**CITY OF PORTLAND
PORTLAND FIRE DEPARTMENT**

Inspection Violations

Owner/Manager RICE GEOFFREY I		Inspector Christopher Champagne	Inspection Date 7/5/2016
Location 197 PLEASANT AVE	CBL 132 J001001	Status Failed	Inspection Type Fire Company-FP Routine Inspec

197 PLEASANT AVE
SECOND FLOOR

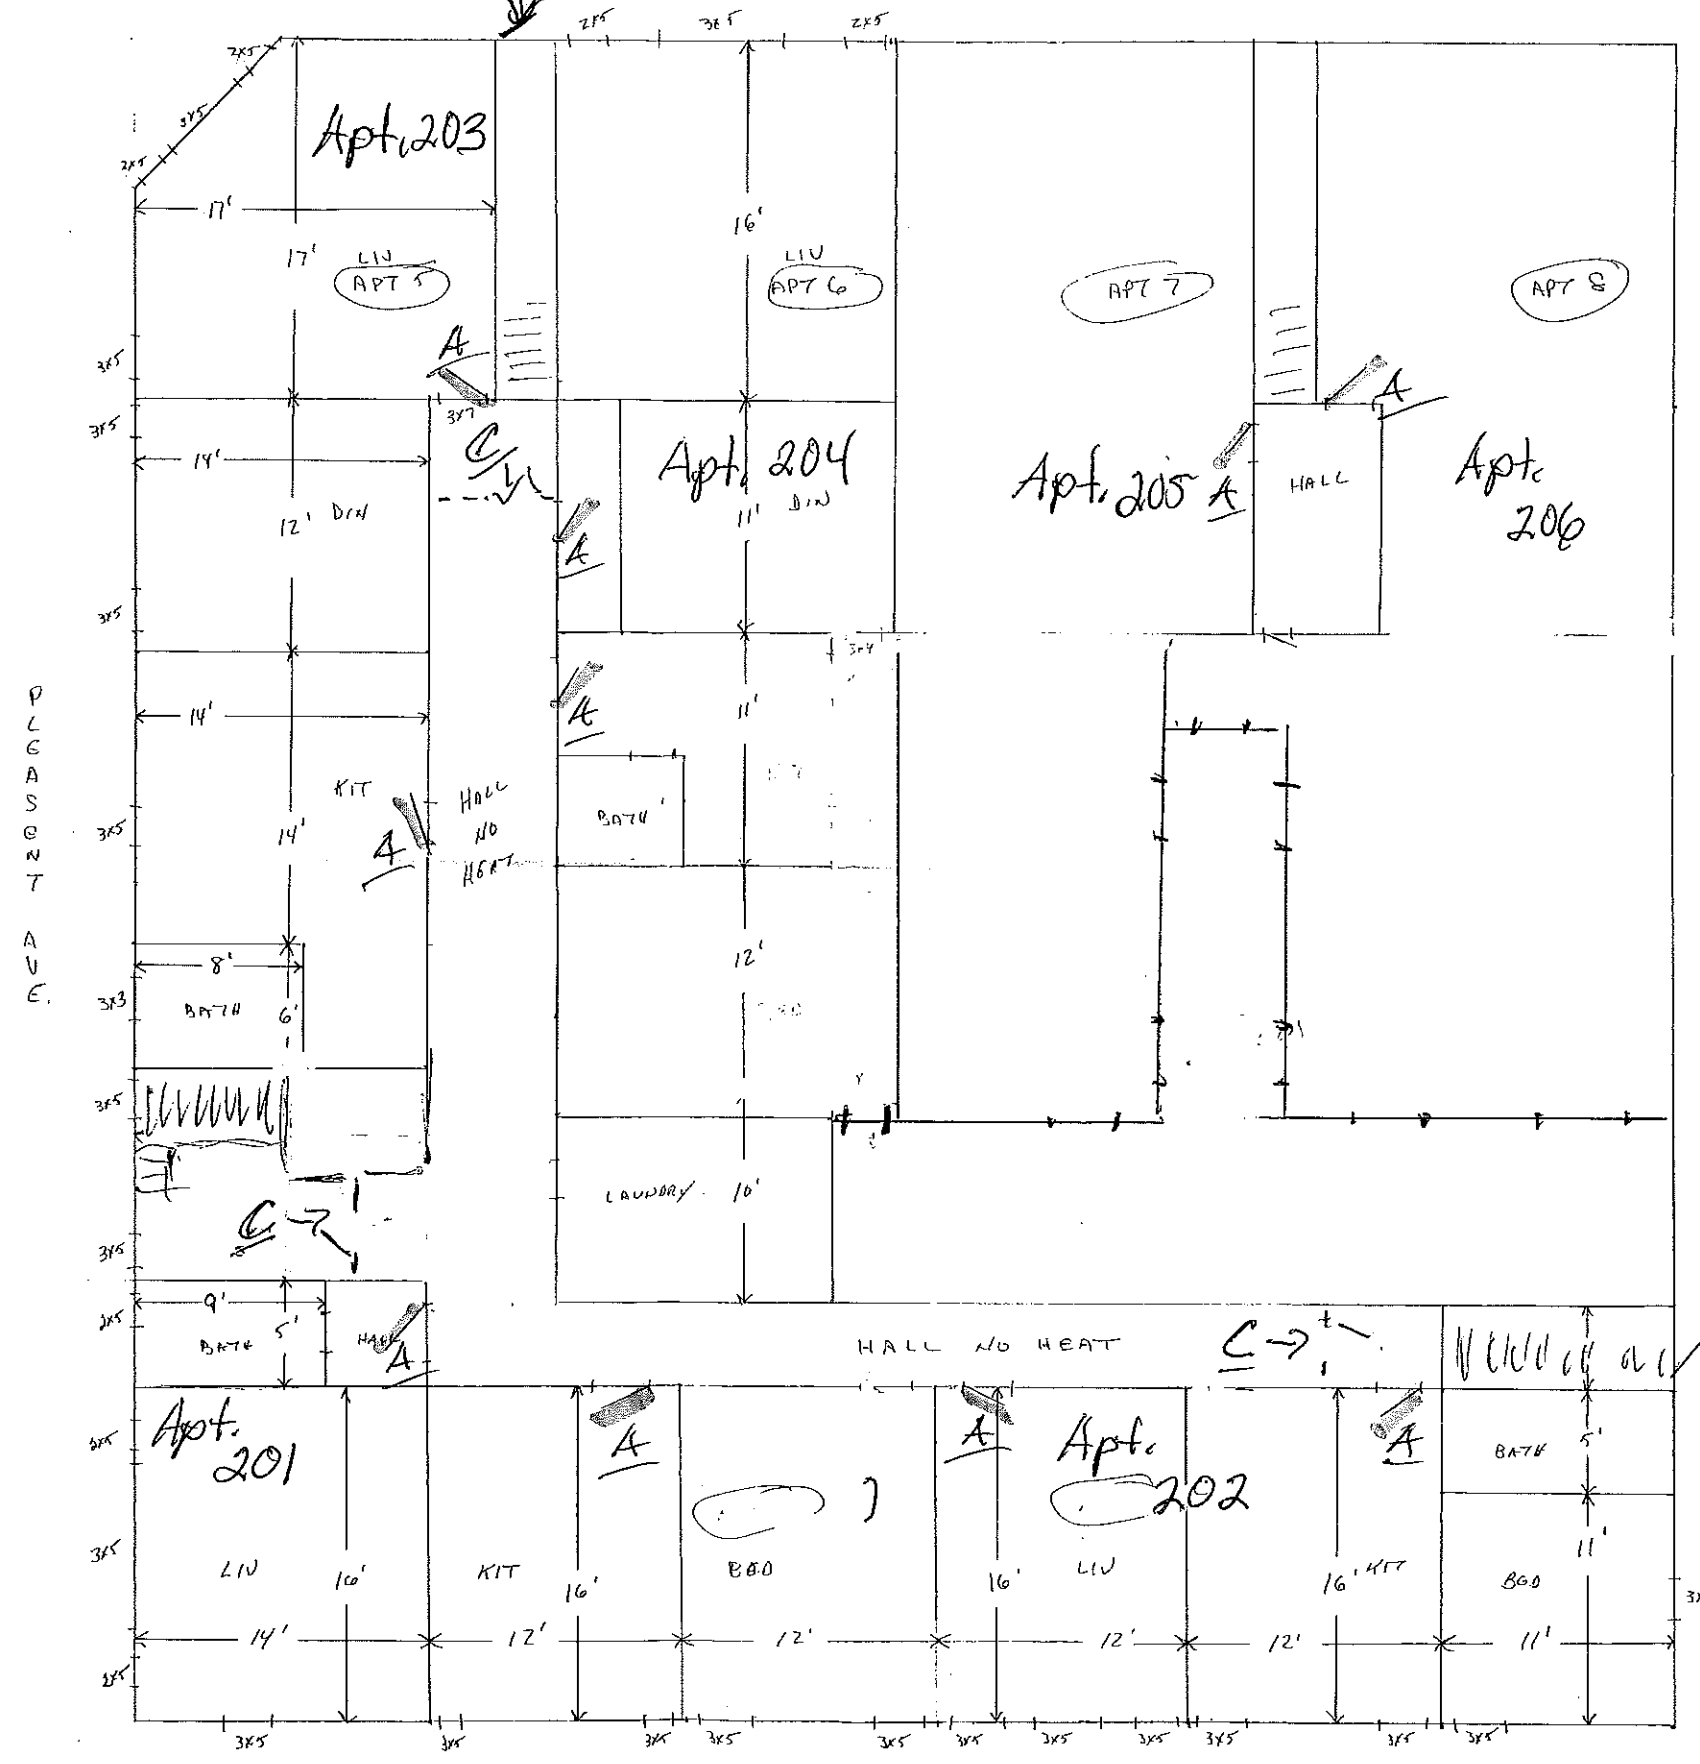
6) 55.040 Interior
Violation: NFPA 101- 31.3.1.1 VERTICAL OPENING VIOLATIONS; VERTICAL OPENINGS SHALL COMPLY WITH 31.3.1.1.1 THROUGH 31.3.1.2.
Notes: VERTICLE OPENING VIOLATION--1 HOUR FIRST SEPERATION NEEDED BETWEEN 1ST AND 2ND FLOOR HALLWAYS. ✓

7) 55.140 Interior Laundry Room
Violation: DO NOT USE
Notes: LAUNDRY ROOM ON 2ND FLOOR NEEDS 1 HOUR SEPERATION FROM MEANS OF EGRESS ✓

197 PLEASANT AVE
FIRST FLOOR

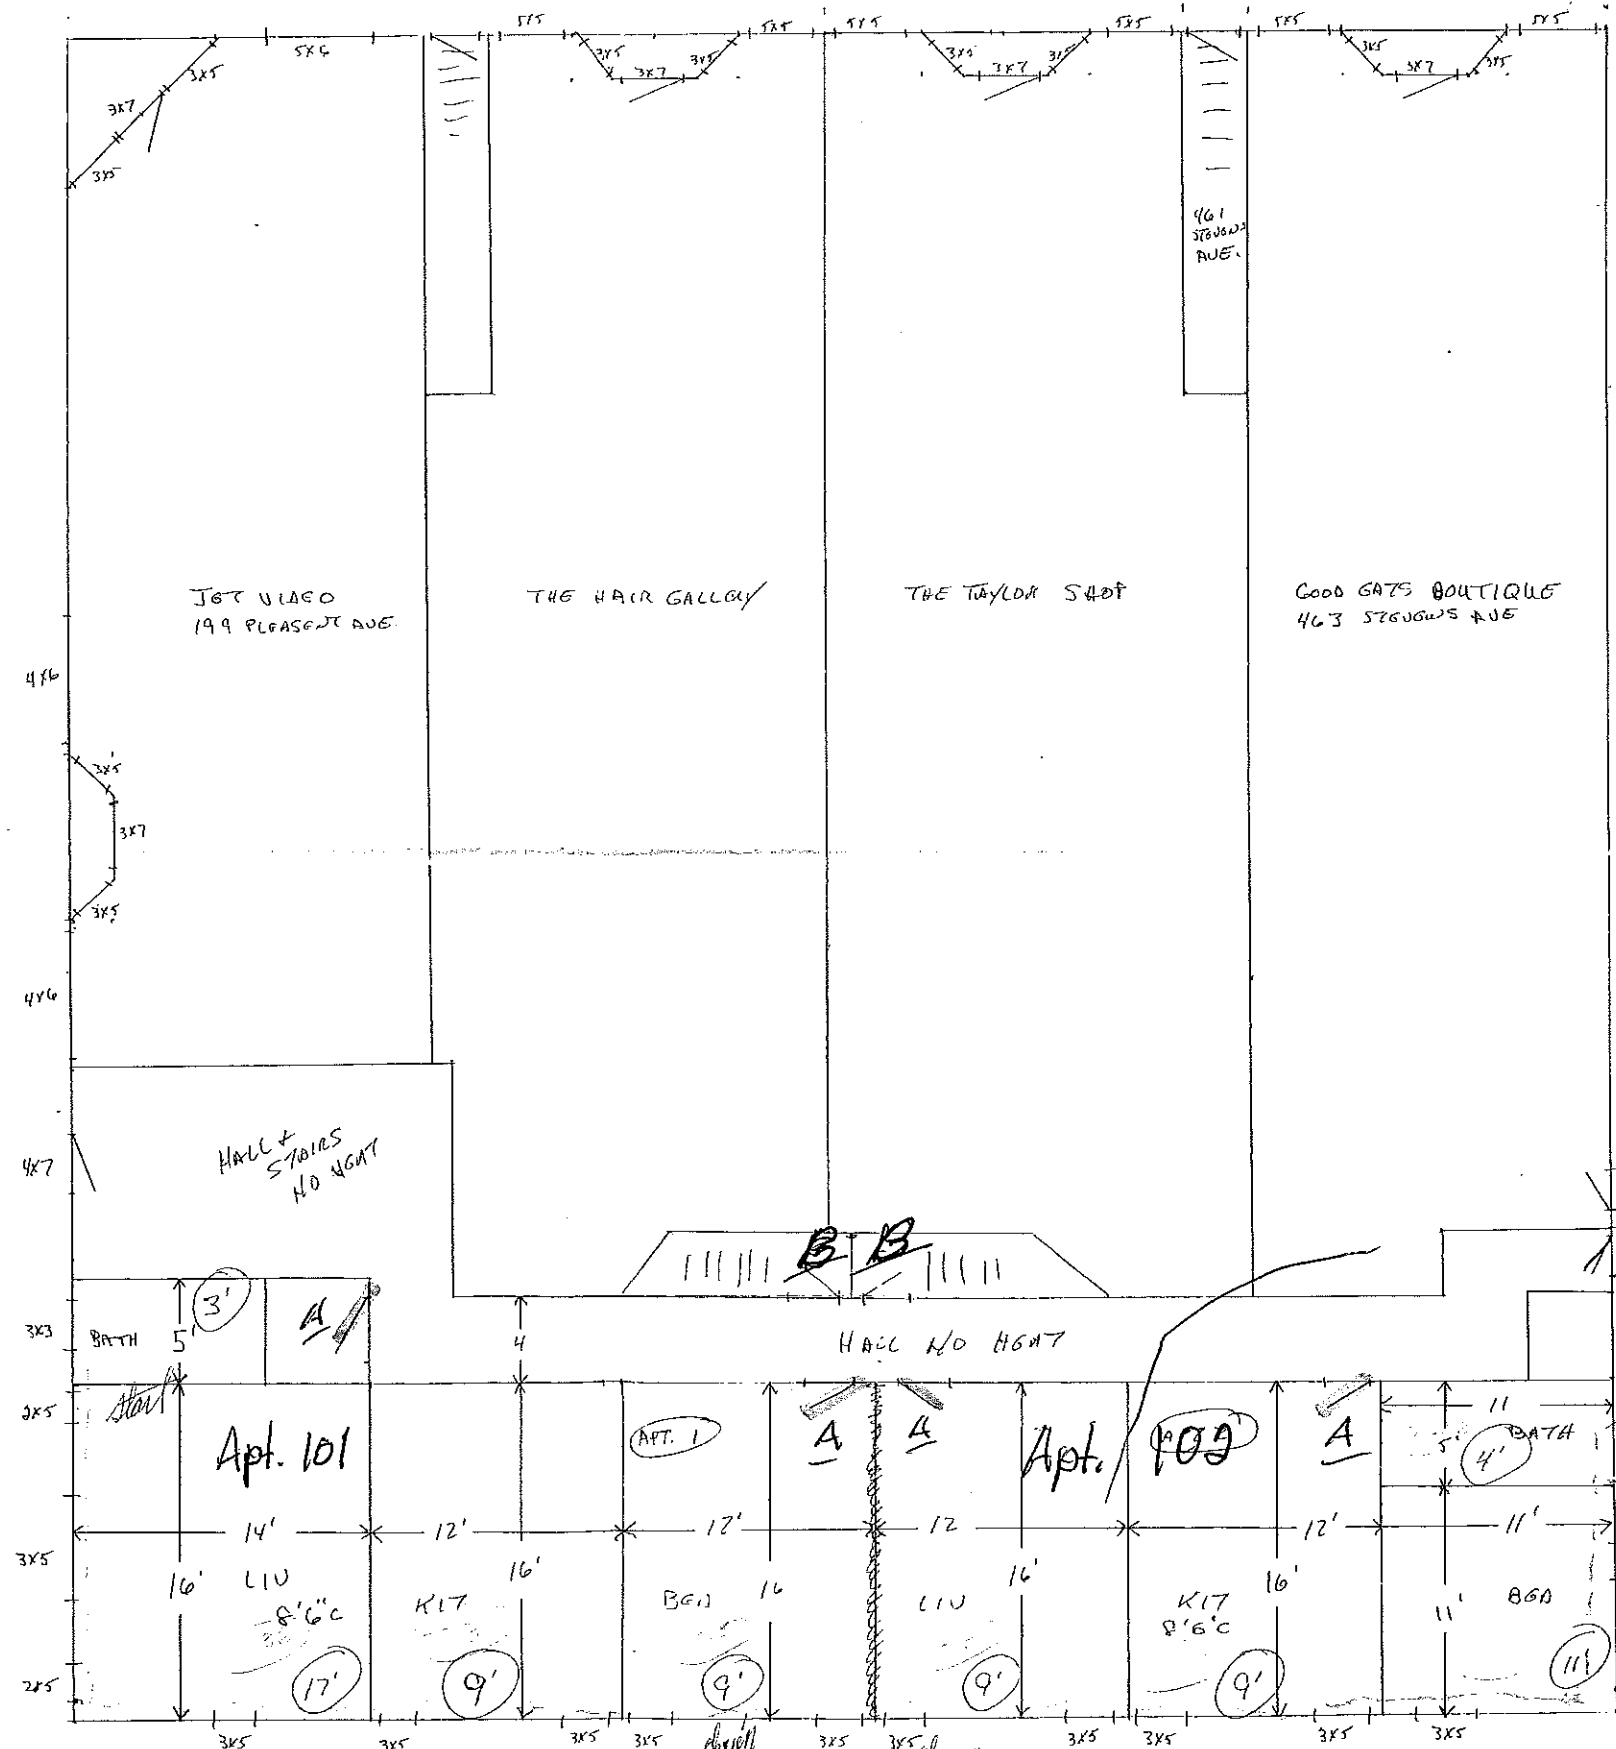
5) 55.125 Interior
Violation: NFPA 101- 31.3.6.3.1 REPAIR CORRIDOR WALLS; UNPROTECTED OPENINGS, OTHER THAN THOSE FROM SPACES COMPLYING WITH 31.3.6.3.2, SHALL BE PROHIBITED IN EXIT ACCESS CORRIDOR WALLS AND DOORS.
Notes: REPAIR CORRIDOR WALLS---HOLES IN BASEMENT STAIRS, FILL CHASES IN BASEMENT, HOLE IN MOP ROOM CLOSET IN FIRST FLOOR HALLWAY. ✓
